Sent: 05 July 2012 21:41
To: Planning
Subject: ✓ Welwyn Hatfield Council Online Planning - Comment

Application Number: S6/2012/1142/FP

Address: 10 Wilkins Green Lane

Comment: As the owners of no.10 Wilkins green Lane we would like to give our objections to the proposed extension/development of no. 9.

TITLE
PROPOSED
REAR & SIDE ELEVATIONS

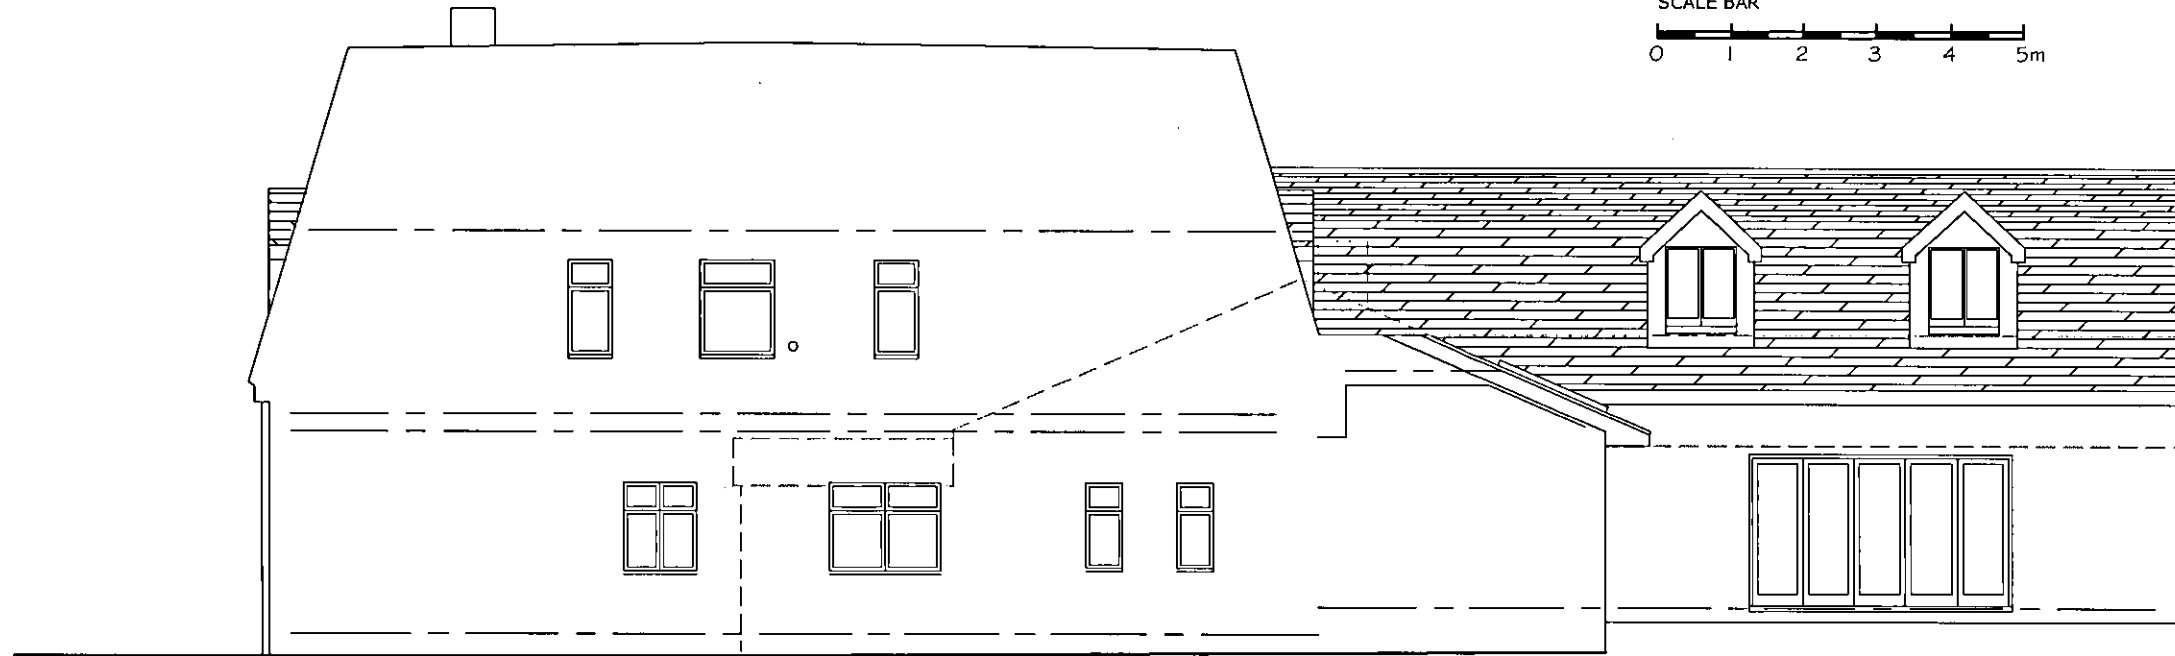
The proposed second floor rear and side windows will over look our front bedrooms. This will mean that we will both lose privacy. This is contrary to policy D1 of the district plan and paragraph 5.7 of the current SPG.

TITLE
 PROPOSED
 ROOF PLAN

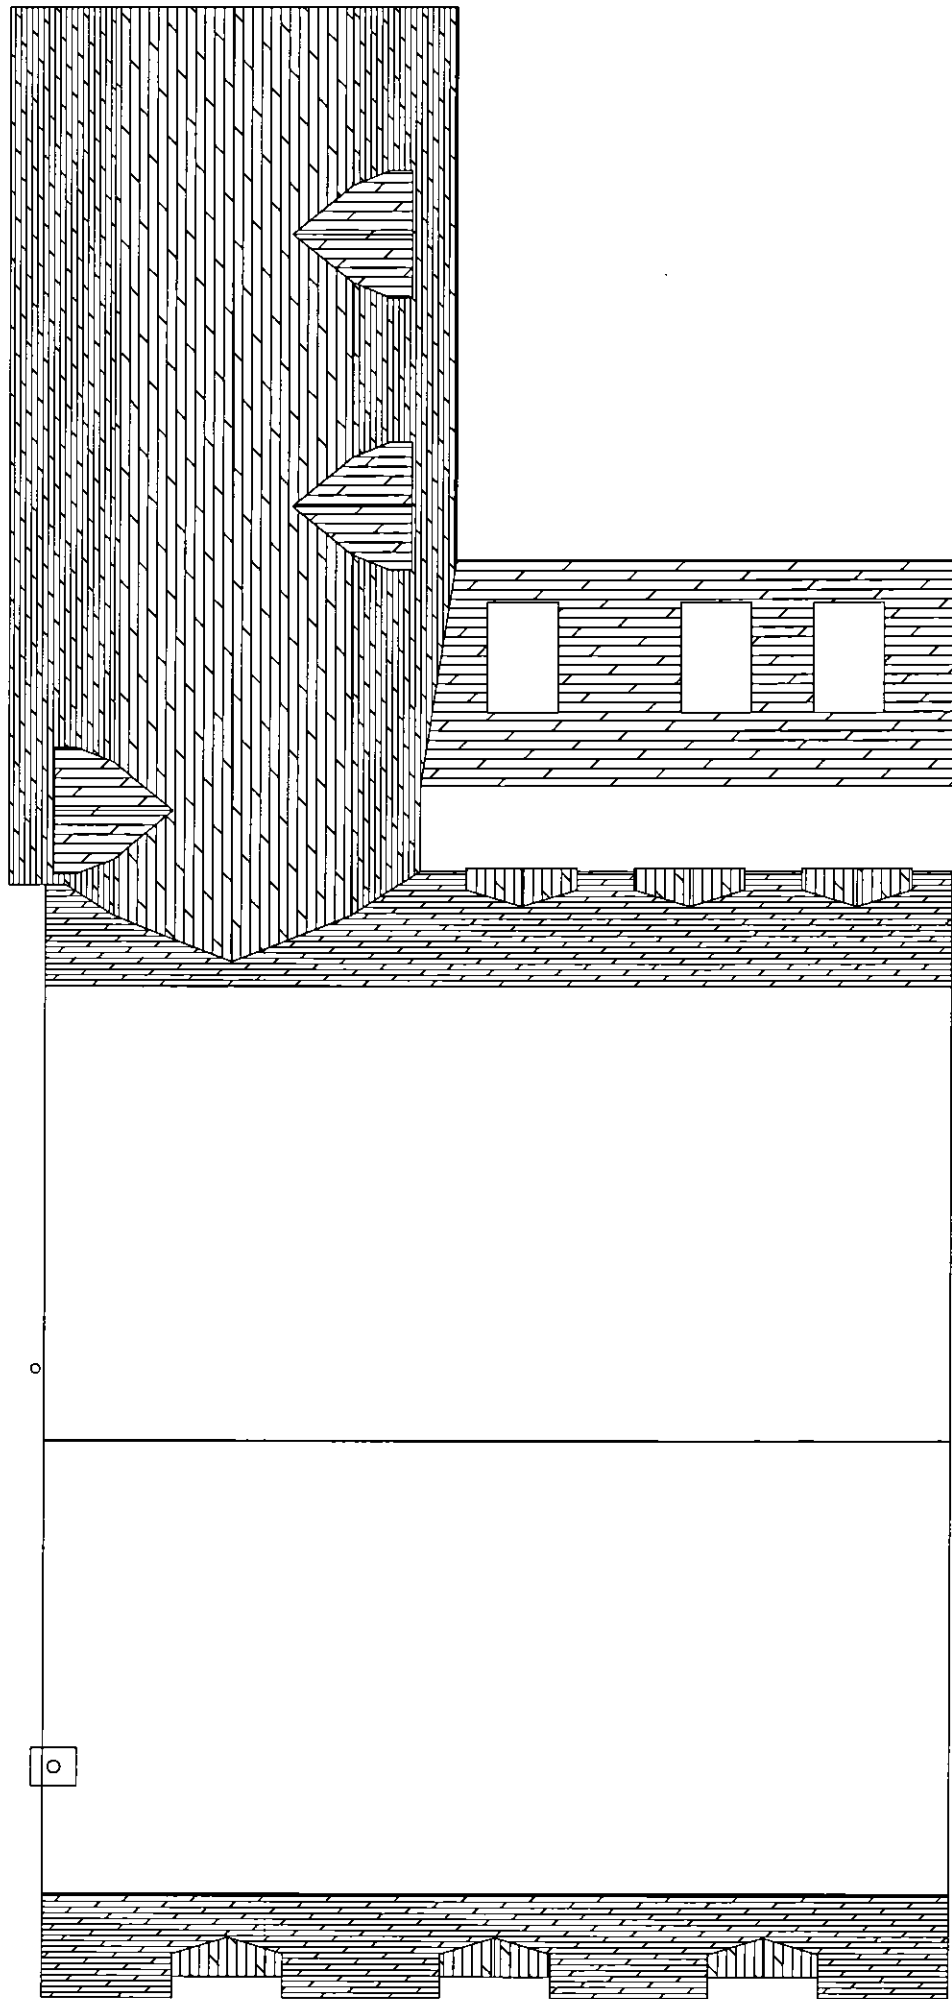
The proposed build is far too big for the size of the plot as there will be very little space between our boundaries. The huge increase in depth and height will mean the property will be completely out of scale for the plot. The increase of ridge height will mean that it will be twice as high as it has been for the past 50+ years and will be overbearing and will have a huge impact on our property.
